Arun Parks and Landscapes response

From: Sue Howell <Sue.Howell@arun.gov.uk>
Sent: 03 April 2025 19:17
To: Planning.Responses <Planning.Responses@arun.gov.uk>
Cc: Simon Davis <Simon.Davis@arun.gov.uk>
Subject: Planning Consultation on: P/114/24/RES

Description: Reserved matters application (pursuant to outline permission P/178/21/OUT (APP/C3810/W/22/3302023)) for matters of appearance, landscaping, layout and scale concerning the construction of 95 new homes along with new pedestrian and cycle links, open space, landscaping, habitat creation, drainage features and associated groundworks and infrastructure. This development is in CIL zone 5 (CIL liable as new dwellings) and may affect the setting of listed buildings.

Location: Land West of Pagham Road Pagham

Play & Recreation

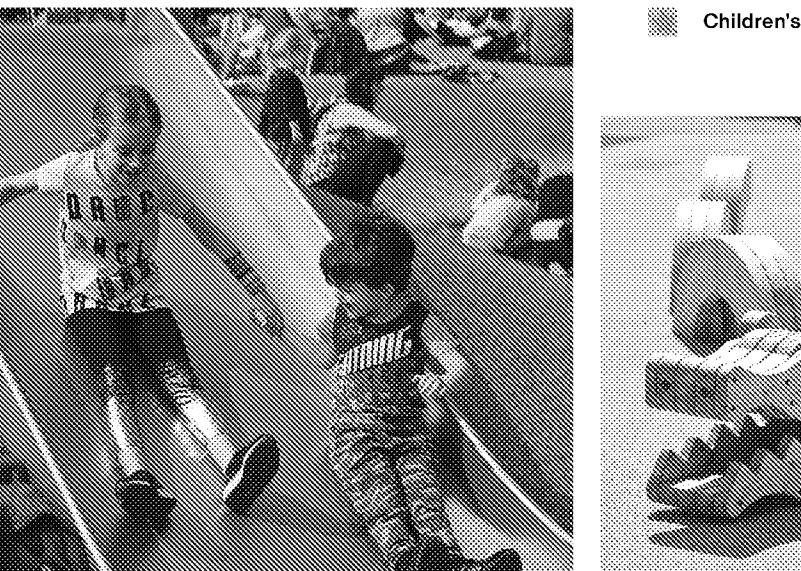
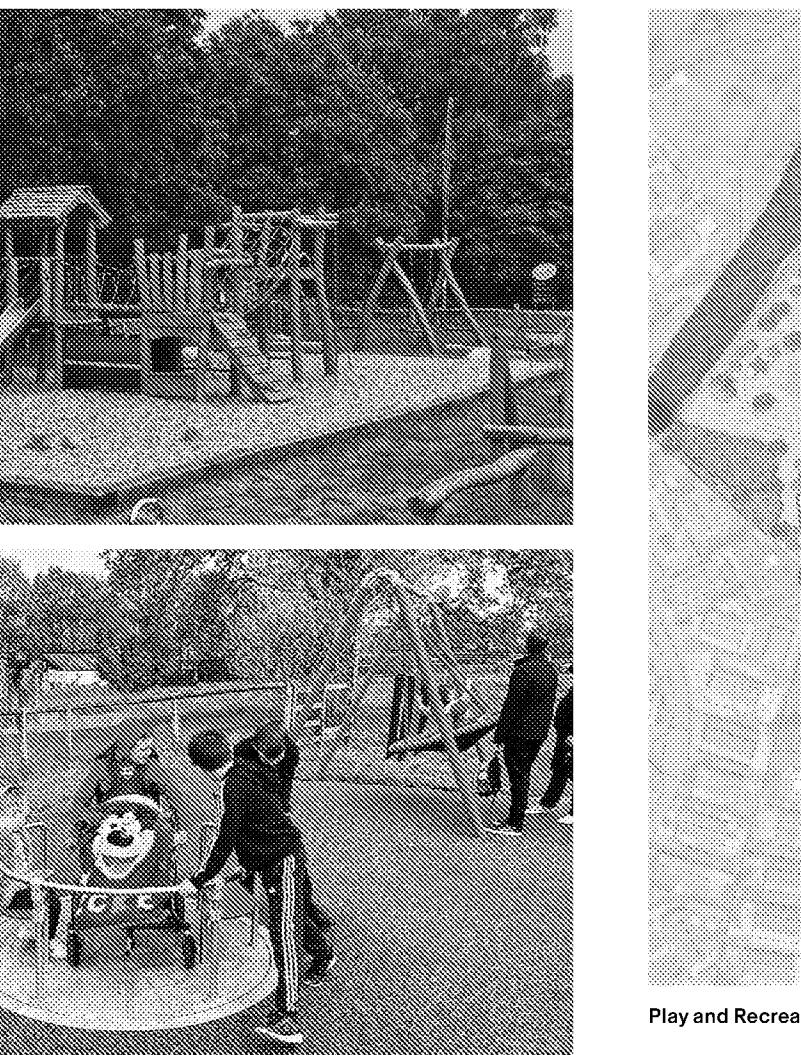
The play offer proposed within the Play area proposals D3322-FAB-00-XX-DR-L- 2000 PL03 still remains **disappointing and falls significantly short of expectation and that which was previously shown and discussed. The proposals whilst amended still does not provide a well thought out scheme which whilst has included elements of inclusive accessible play is not challenging or zoned in areas, does not provide a strong theme and is lacking in a bespoke element to bring forward a challenging and quality scheme.**

The main access pathway from Pagham Road is shown to run through the fenced play area. General access pathways should not run within the fenced area of the play area and needs to be amended to divert the pathway or repositioned fencing to allow the access path to run externally to the play area.

Play – LEAP detail to be conditioned for further submission and approval.
